January 27, 2020

LETTER OF INTENT: SPACE VILLAGE APARTMENTS VARIANCE OF USE

OWNER: Bridle Dale, LLC
 Address: 6875 & 6895 Space Village Drive
 Colorado Springs, CO 80936
 Parcel ID #: 54170-000-019
 Zoning: CC (Commercial Community) District
 Acreage: 0.628 acres (survey performed by Drexel Barrell & Co.)

VARIANCE SITE PLAN
V1

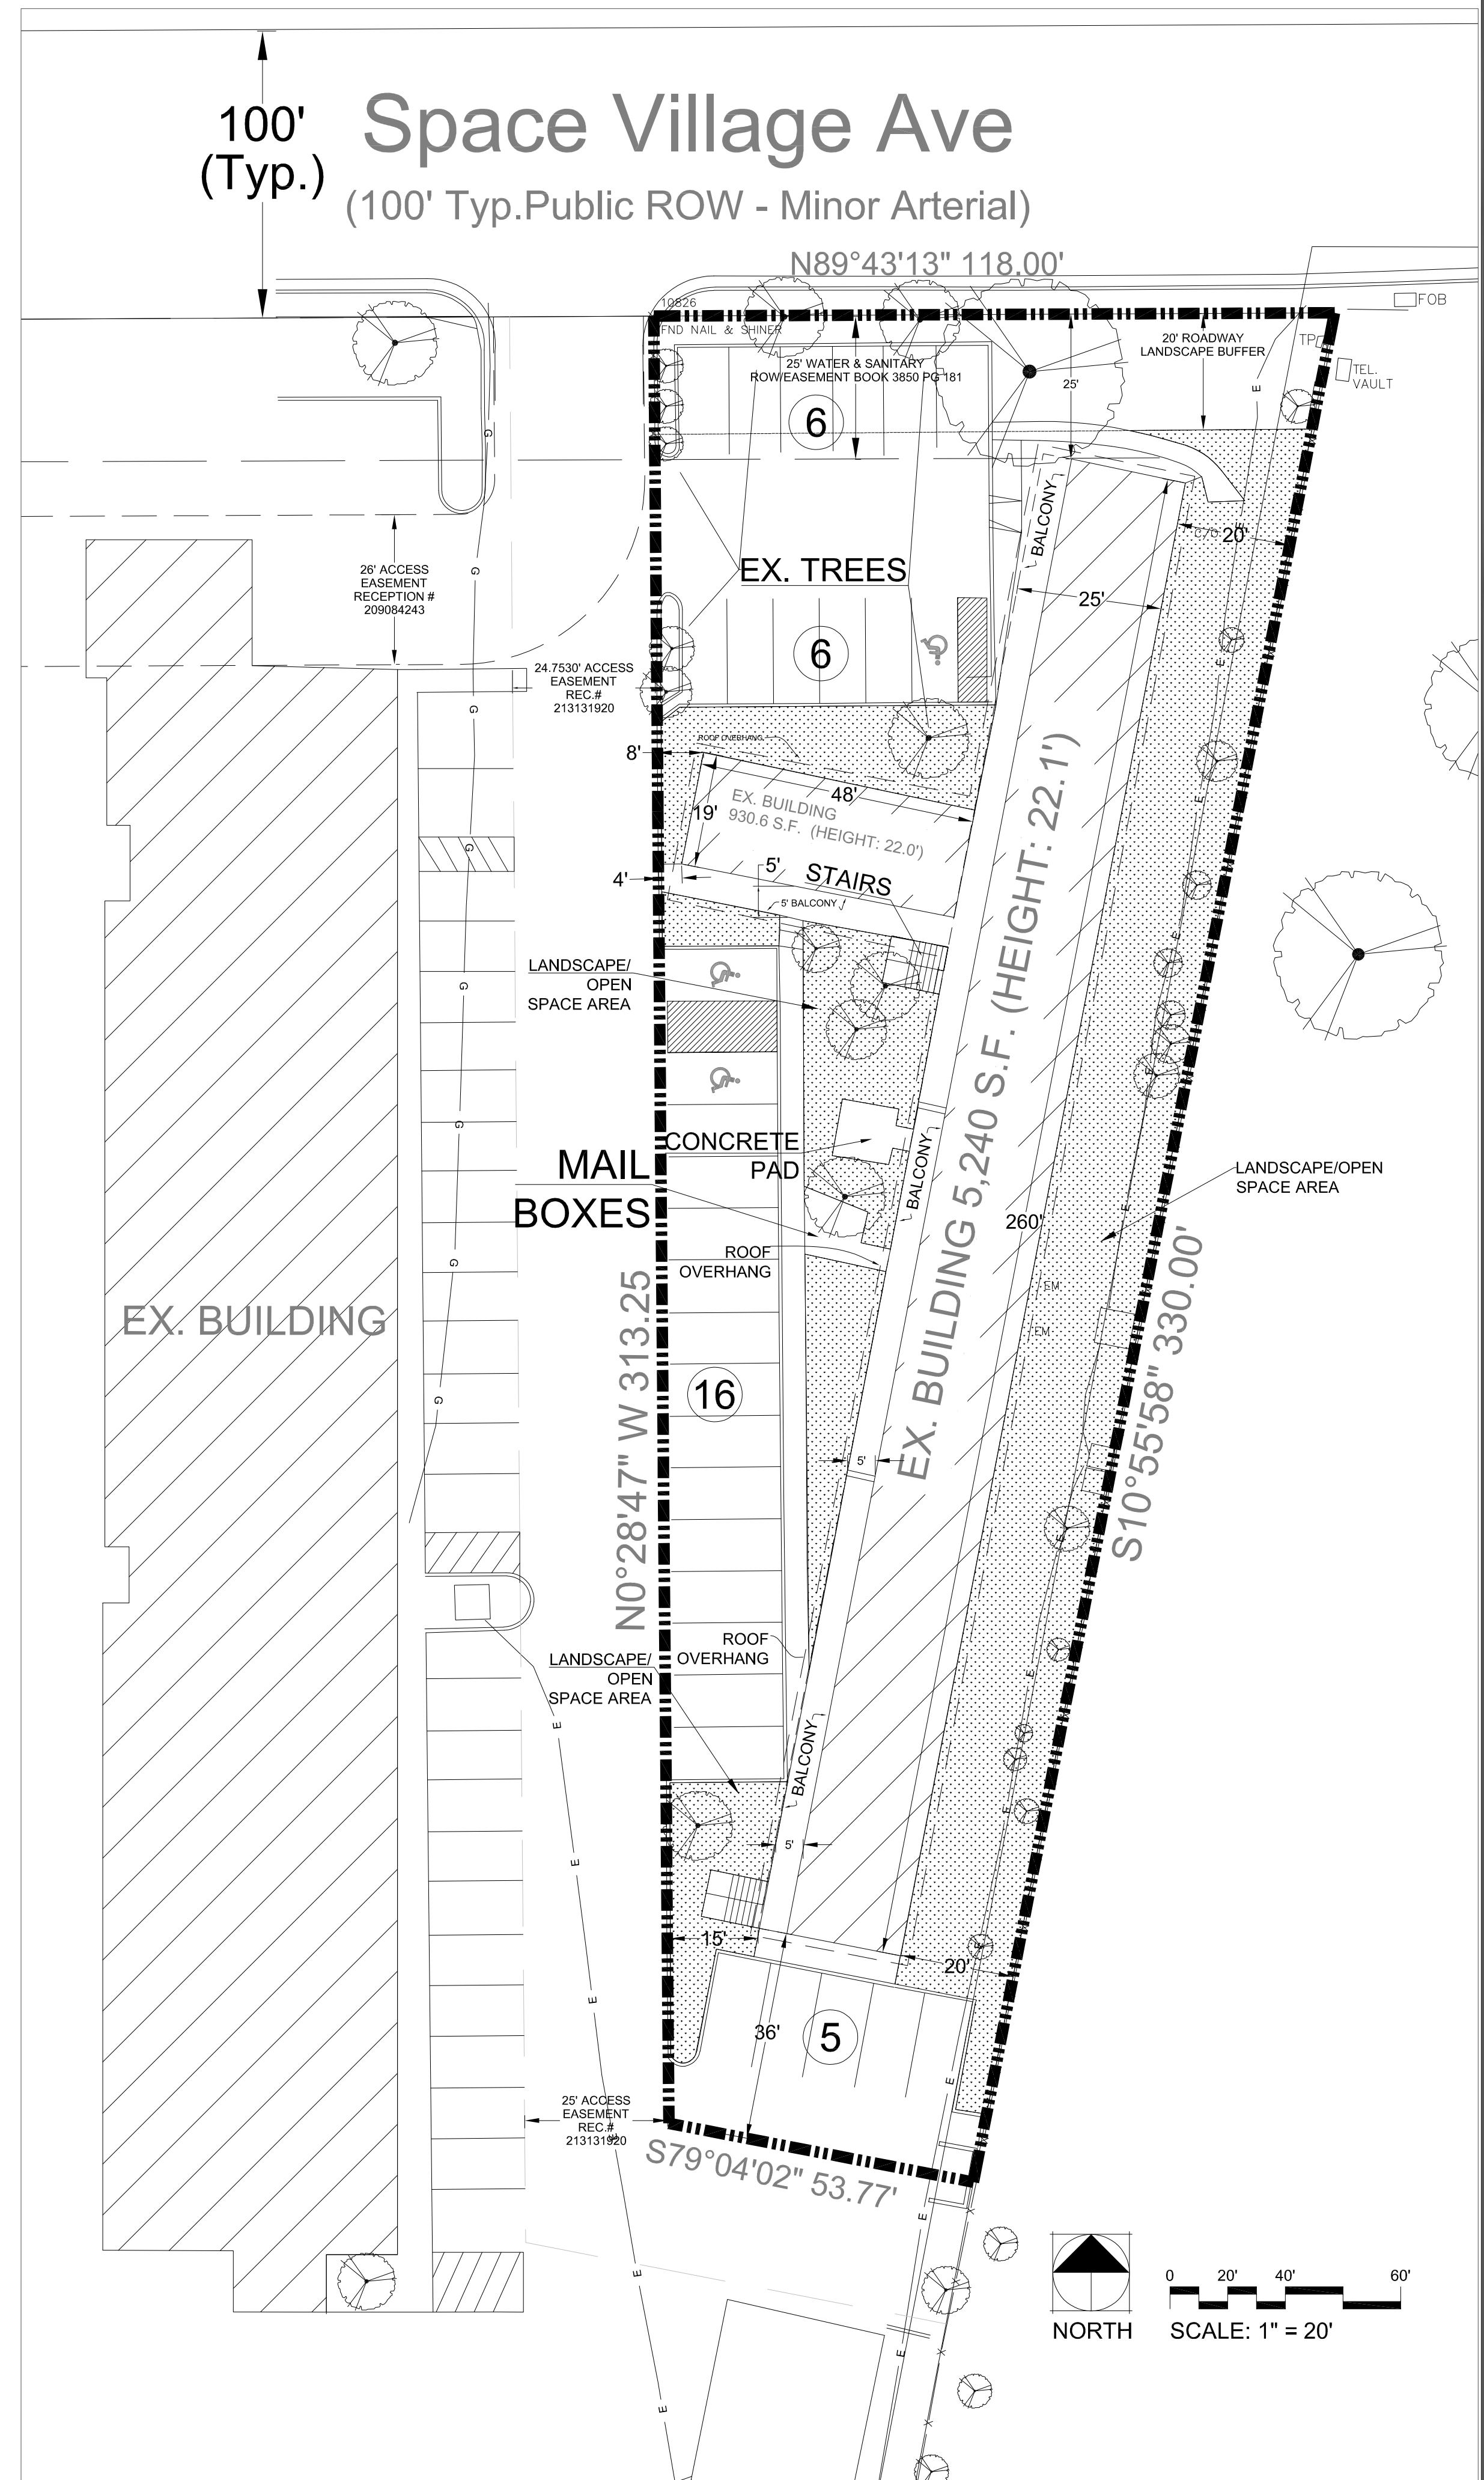
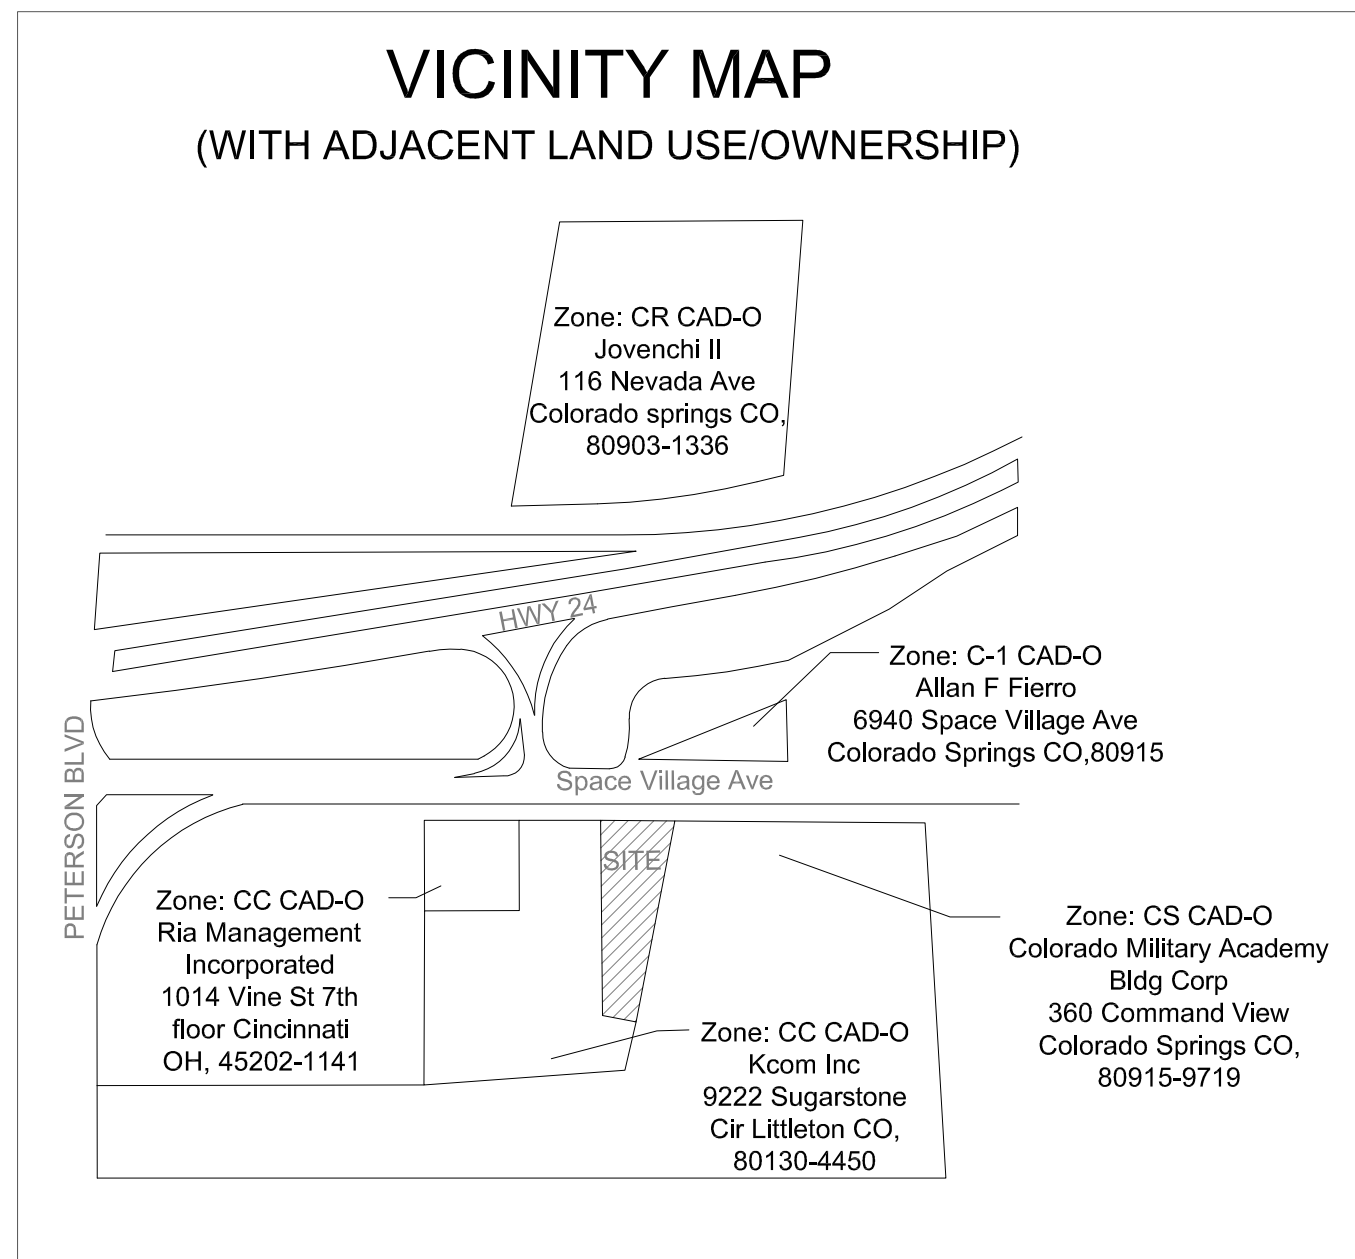
Provide justification, is there a shared parking agreement with the neighbor?
